Our Reference: ORML2429T

MARINE AND COASTAL ACCESS ACT 2009: PART 4 – MARINE LICENSING

Marine licence Application ORML2429T - works associated with the construction and maintenance of the transmission assets of the Mona Offshore Windfarm Project.

Figure 1.1: Location of proposed Mona Offshore Cable Corridor disposal site.

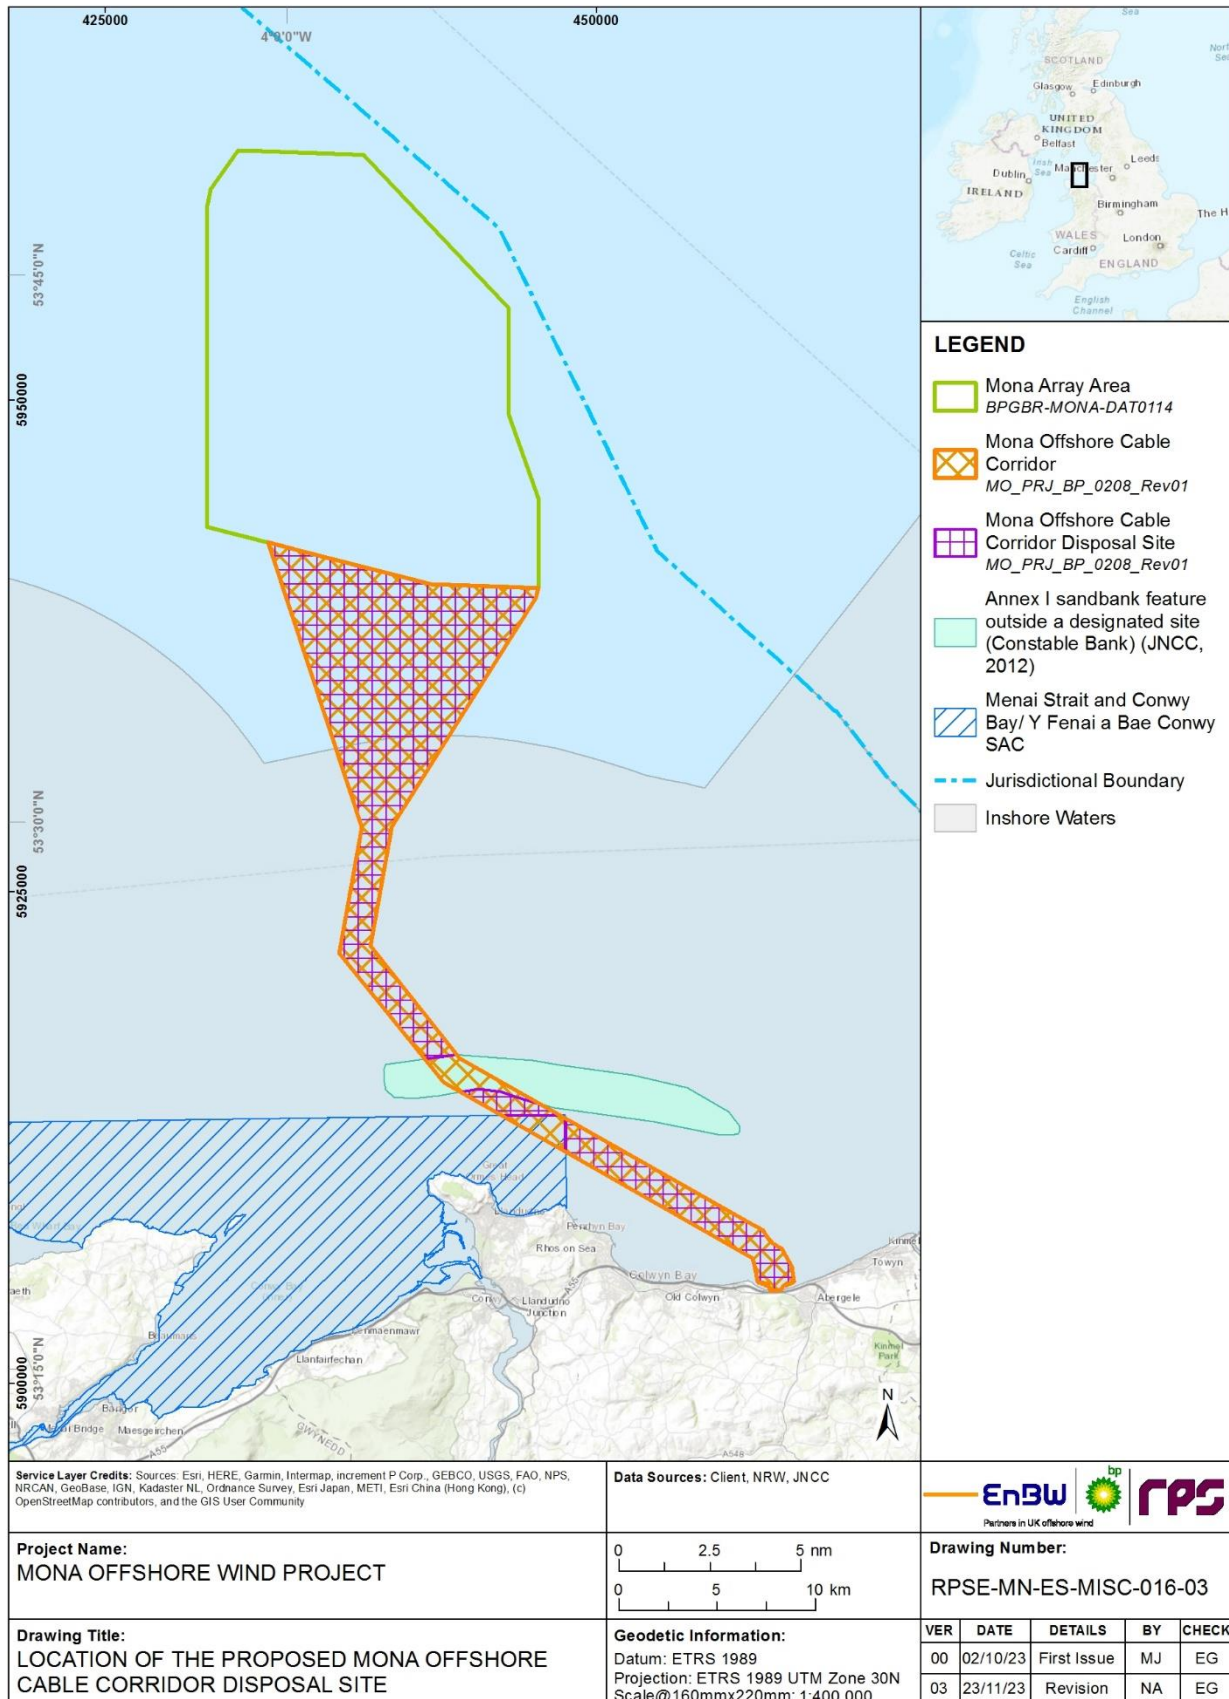
The marine licence application form section 11 makes clear that dredging and disposal associated with the Offshore Substation Platforms are applied for as part of the transmission licence. However this does not appear to be reflected within section 1.1.1.5 of document J20 Mona Offshore Cable Corridor Site Characterisation Report.

Whilst the marine licence for the Mona Offshore Cable Corridor will also cover the transmission infrastructure within the Mona Array Area, the Mona Offshore Cable Corridor disposal licence will only cover disposal activities within the Mona Offshore Cable Corridor.

Please provide clarification surrounding this discrepancy.

Figure 1 location of the proposed Mona array disposal site.

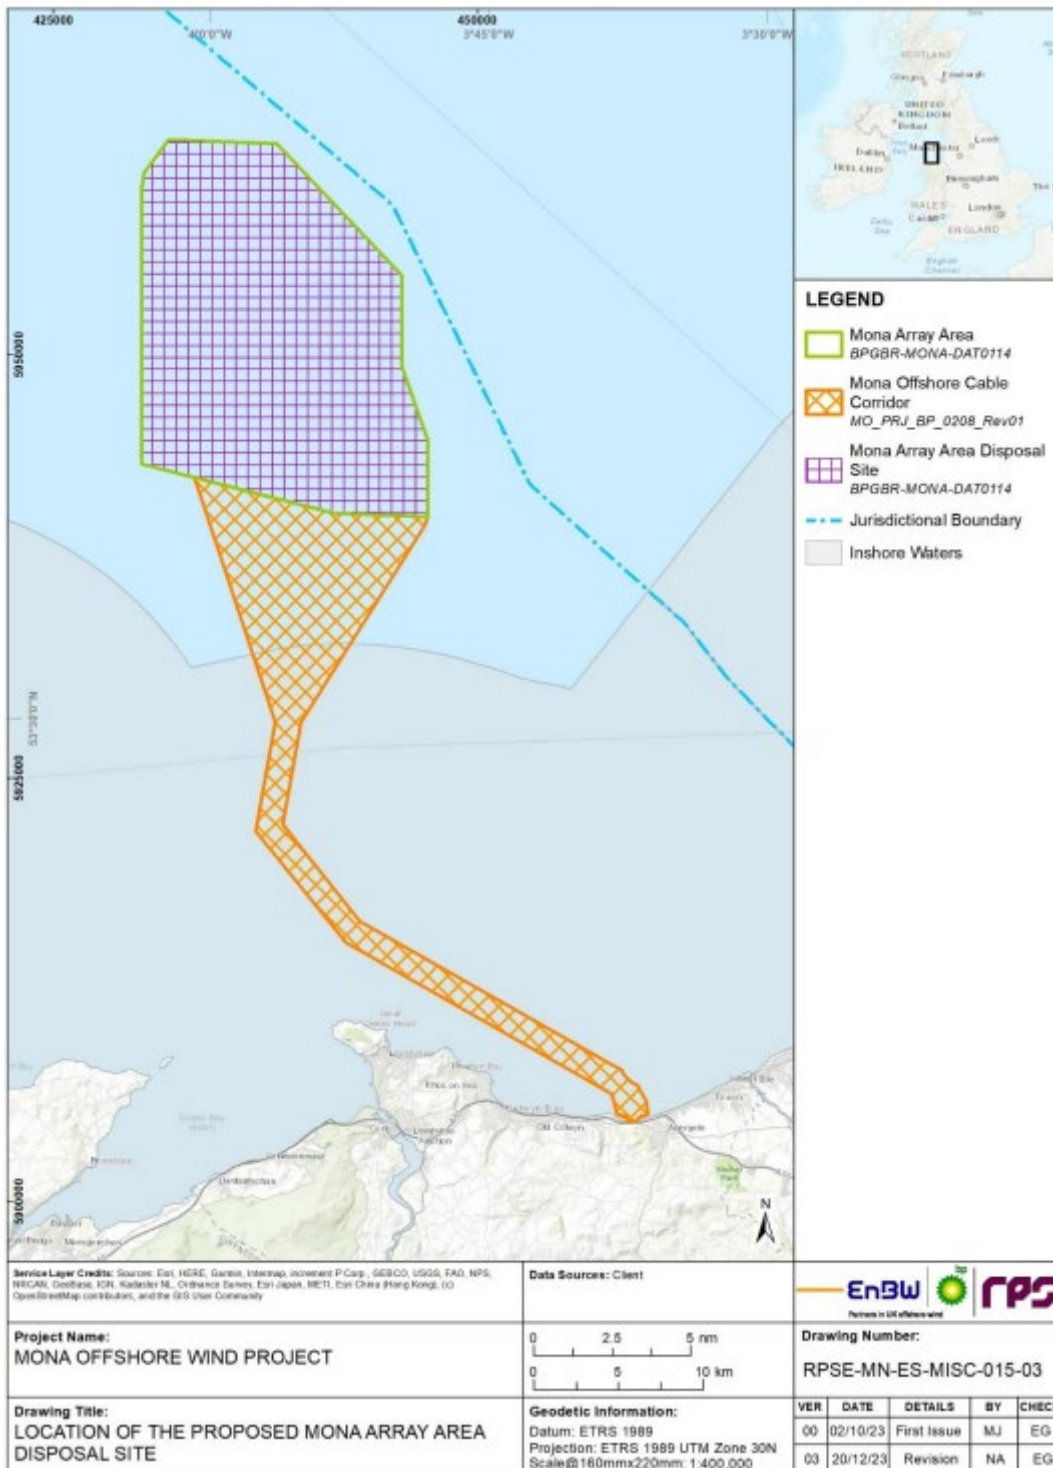
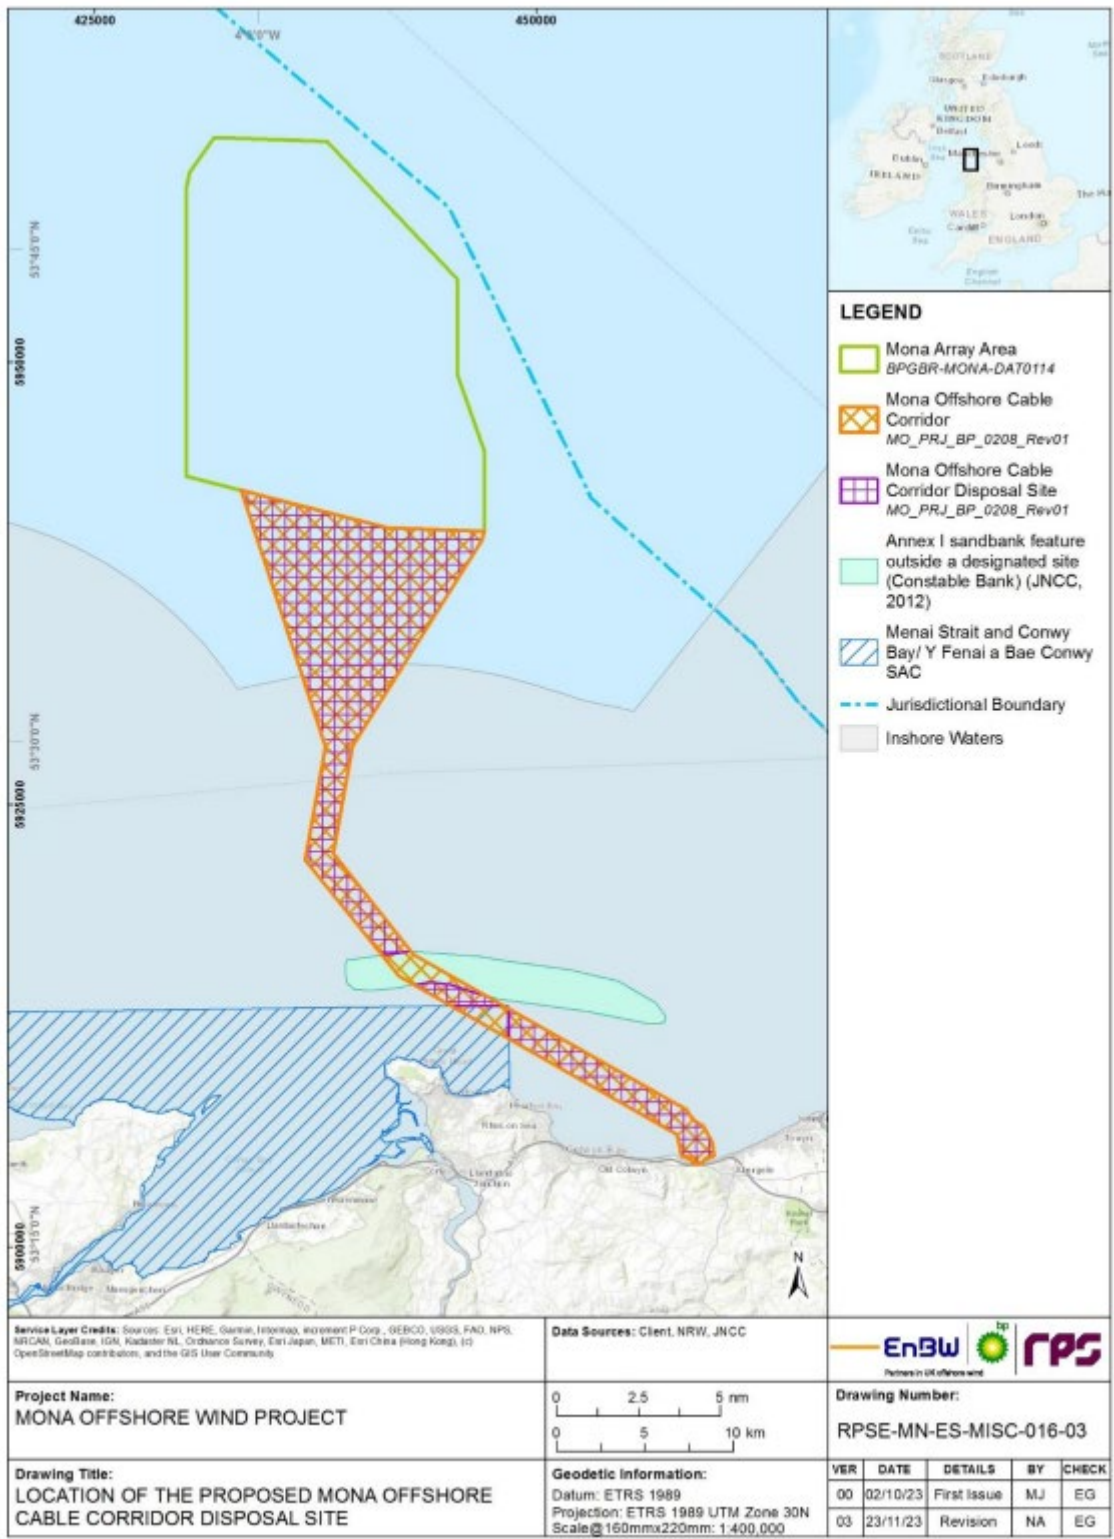
Co-ordinates for the disposal site have currently been split into the two Mona disposal sites, the Mona array area disposal site and the Mona offshore cable corridor disposal site (document A5 Disposal sites co-ordinates). As recommended by Cefas, please provide a single set of co-ordinates to allow one area covering both the array area and offshore cable corridor to be designated. Please submit the coordinates in a spreadsheet as well as a shapefile.

Figure 1.1: WFD coastal and transitional water bodies and coastal waters assessment boundary.

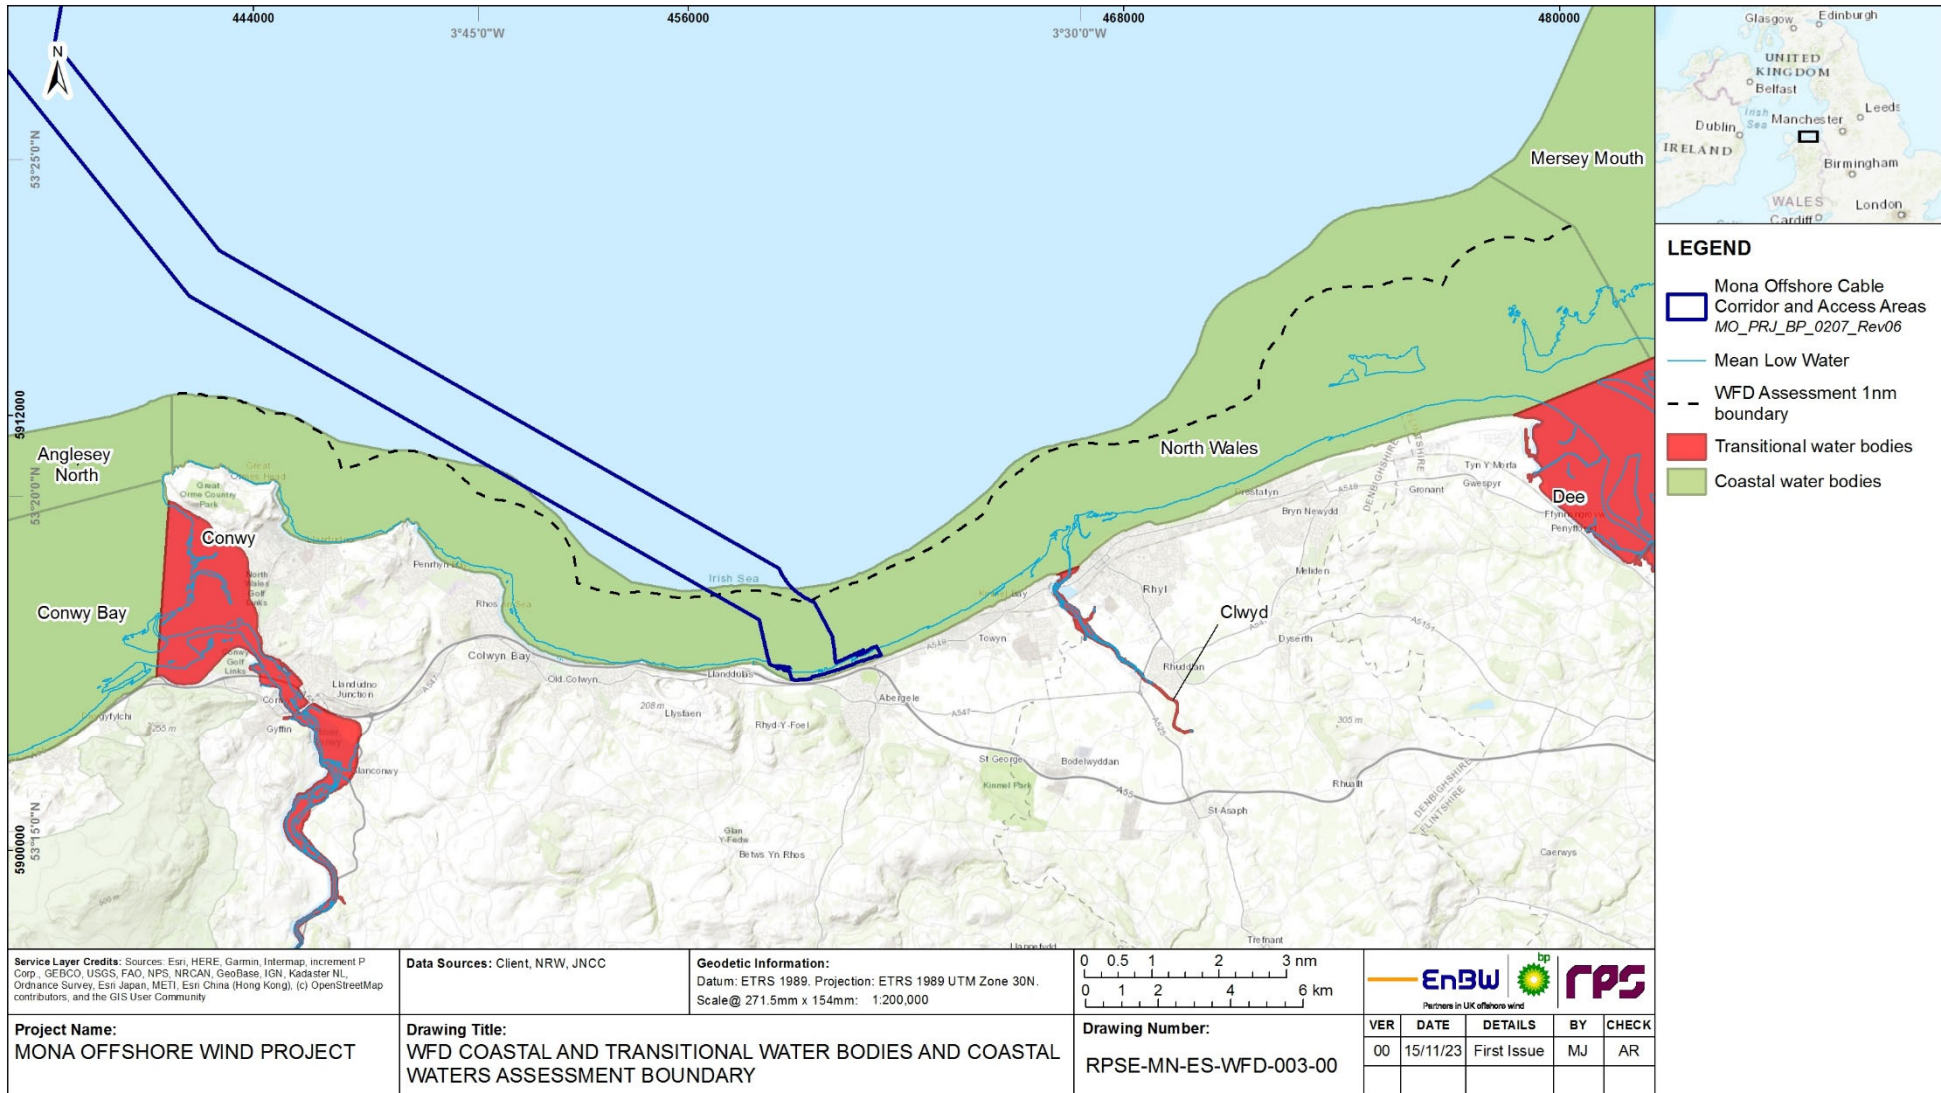
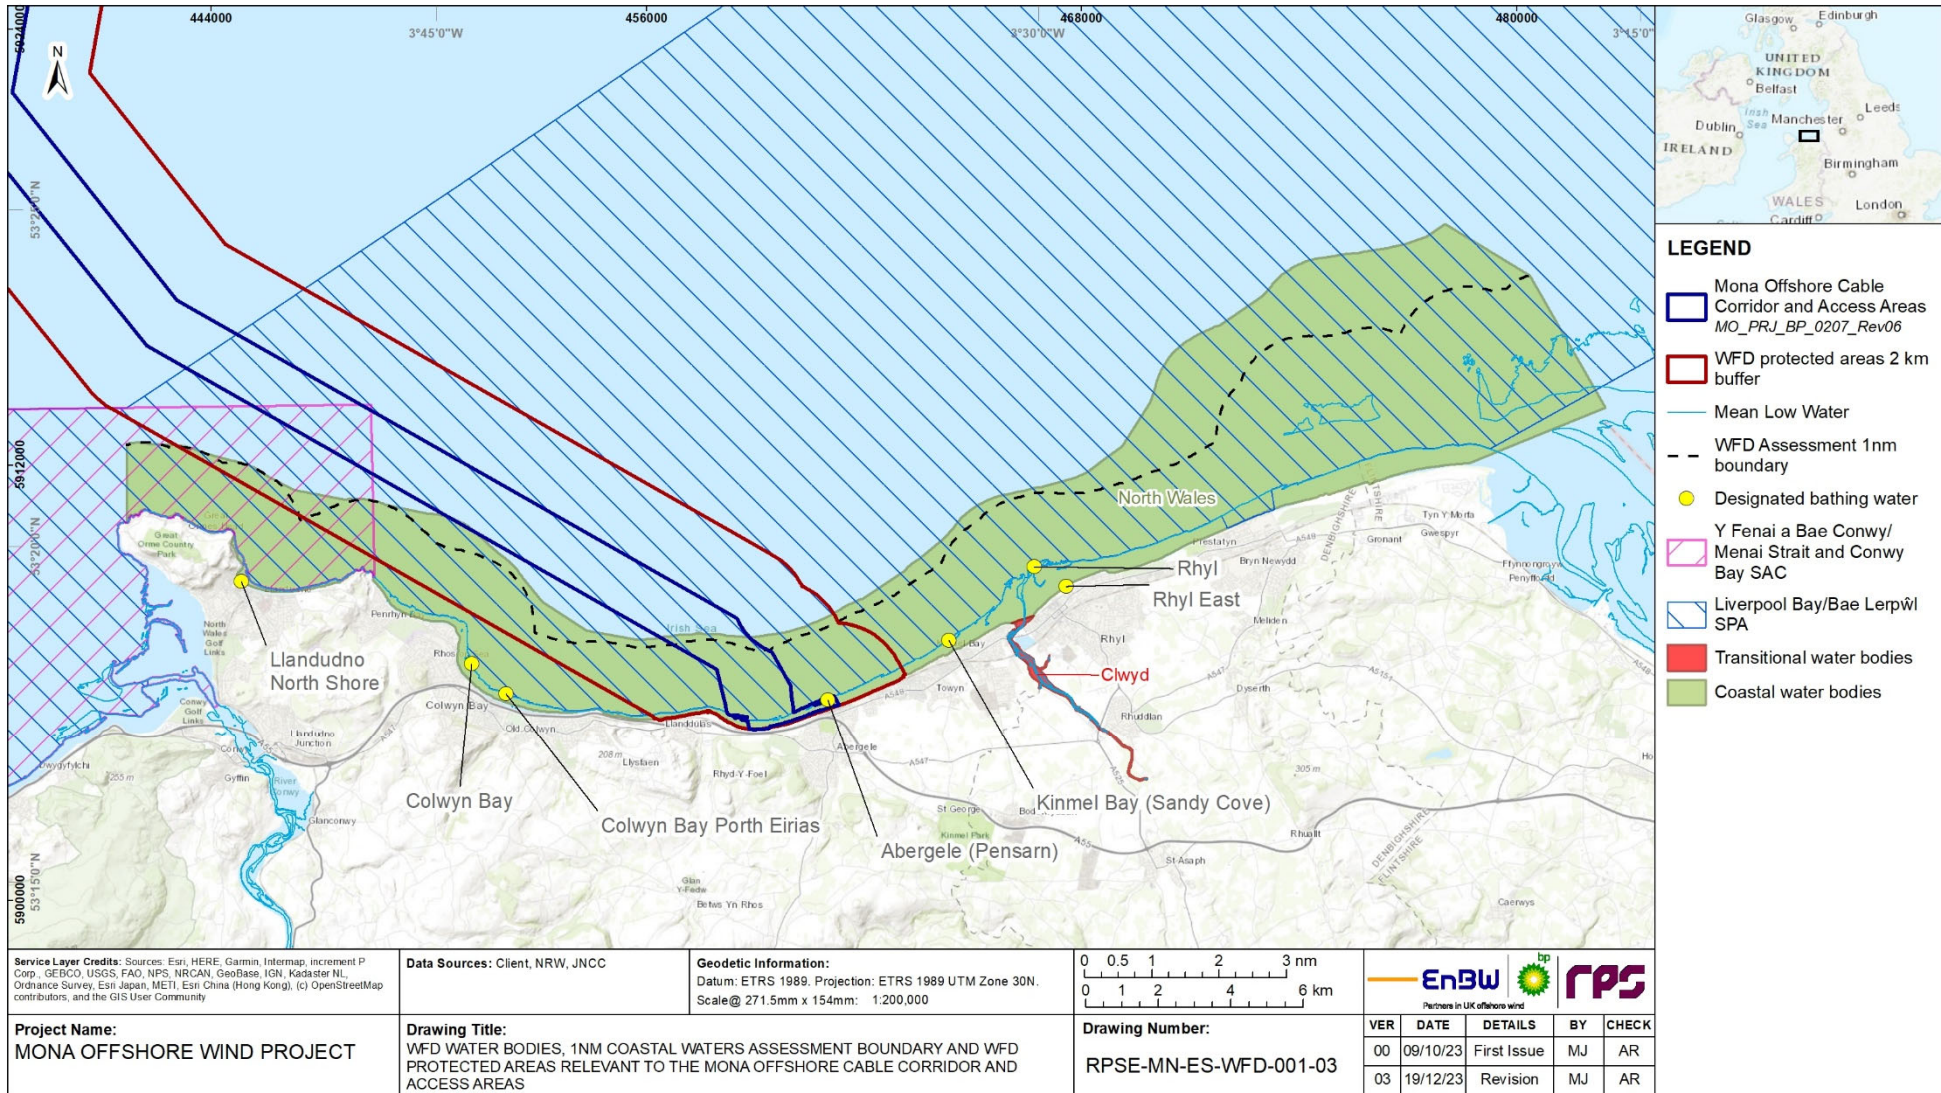
NRW A have raised a number of concerns surrounding the WFD assessment, we ask that you review the consultation response and provide a response or further information to address concerns raised, including ensuring that assessment of chemical contaminants is extended to 12nm from MHWS for compliance with the WFD regulations.
